**Consultation Response from KC,  
Lead Local Flood Authority**

**2024/92568 Land off, Manchester Road, Marsden, Huddersfield, HD7 6NJ**

**Erection of agricultural shed including access and associated works**

**Date Responded: 02/12/2024.**

Proposed section through watercourse (1:200)

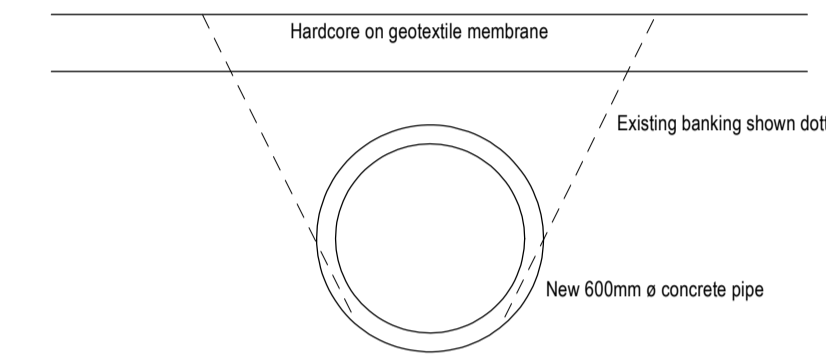
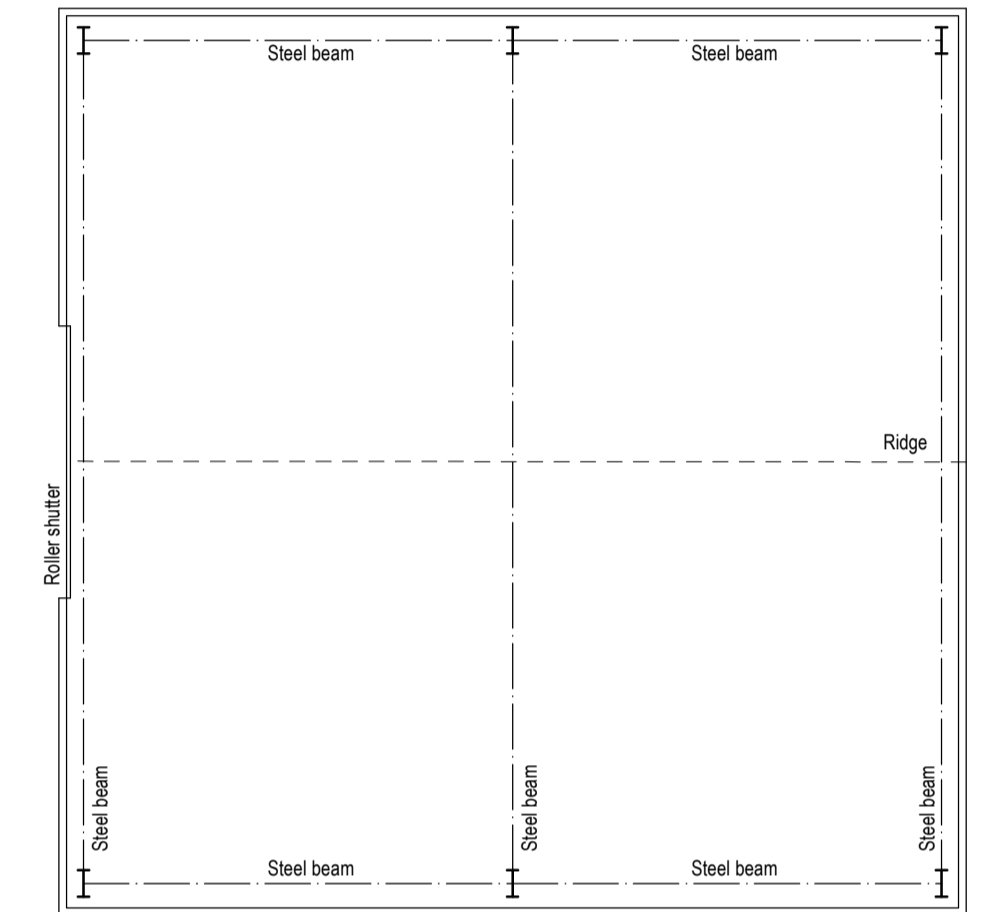
The applicant is proposing to culvert a short length of un-named open watercourse which rises (issues) approx. 32m to the south-west and sinks approx. 60m to the north-east prior to reaching Manchester Road. Part of the watercourse is already culverted under the existing farm access track for an approx. 9m length, and it is proposed to extend this culvert a further approx. 10m to provide access to the new building. The watercourse does not appear to drain any upstream buildings and the proposed culvert is shown on the above drawing to be 600mm diameter which the applicant should ensure has sufficient capacity for the flow from the upstream catchment. The applicant must ensure the proposed culvert is of sufficient strength to accommodate the expected wheel loading from vehicles using the access and will be responsible for its maintenance and repair together with riparian responsibility for the watercourse itself.

The LLFA generally discourages new culverting, however in this instance, there appears to be no alternative method of providing the necessary access.

**Kirklees Flood Management and Drainage as the Lead Local Flood Authority, SUPPORTS this application and has no recommended drainage conditions.**
